From: [REDACTED]
To: [Norfolk Boreas](#)
Subject: Norfolk Boreas Project EN010087.
Date: 01 February 2020 00:21:46

I would like to add if possible to my points regarding the applicant's intended noise management. The applicant's Baseline Noise Survey Appendix 25.1 demonstrates that the 32dB noise limit at residential property is questionable.

From: [REDACTED]
To: [Norfolk Boreas](#)
Subject: Norfolk Boreas Project EN010087
Date: 25 February 2020 22:48:28

SCENARIO 1
Figure: 29.28b (1 of 2)
Viewpoint 6: A47 Top Farm

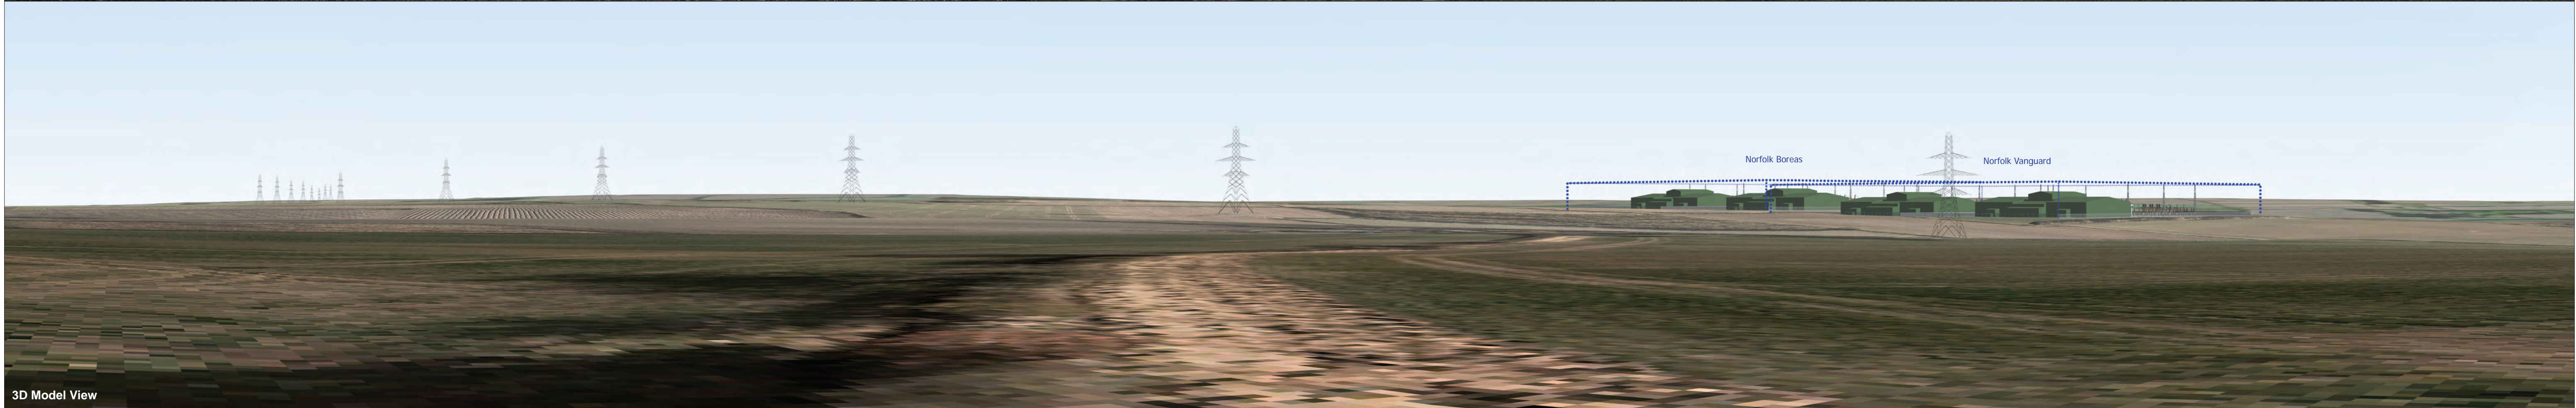
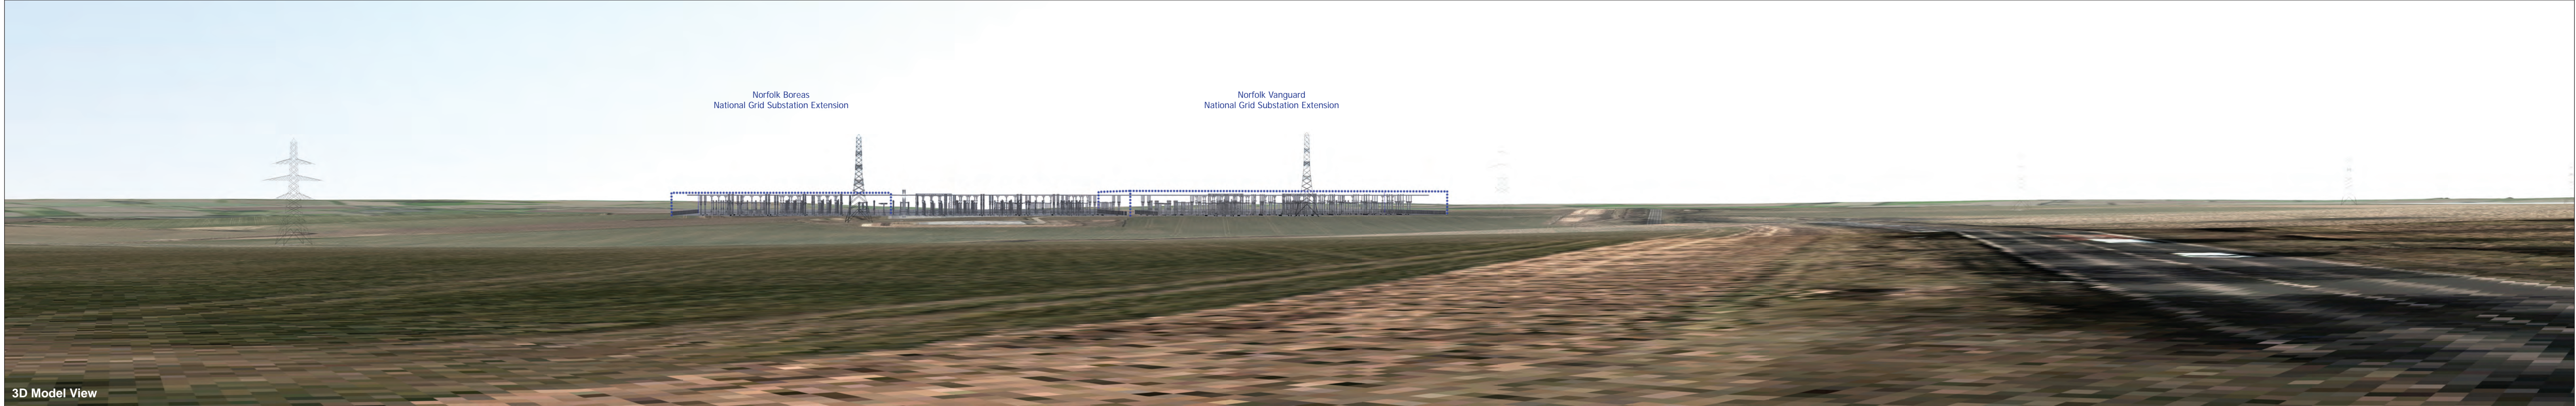
Paragraph 114. states the impact assessments are carried out from observations in the field and may include elements that are not visible in the photographs. This firstly gives the impression the applicant could know relevant information from the in field observations, and is not showing it all in the statement, and secondly the photo montages of viewpoints 3 and 7, I feel should have turned out more accurate and true to life.
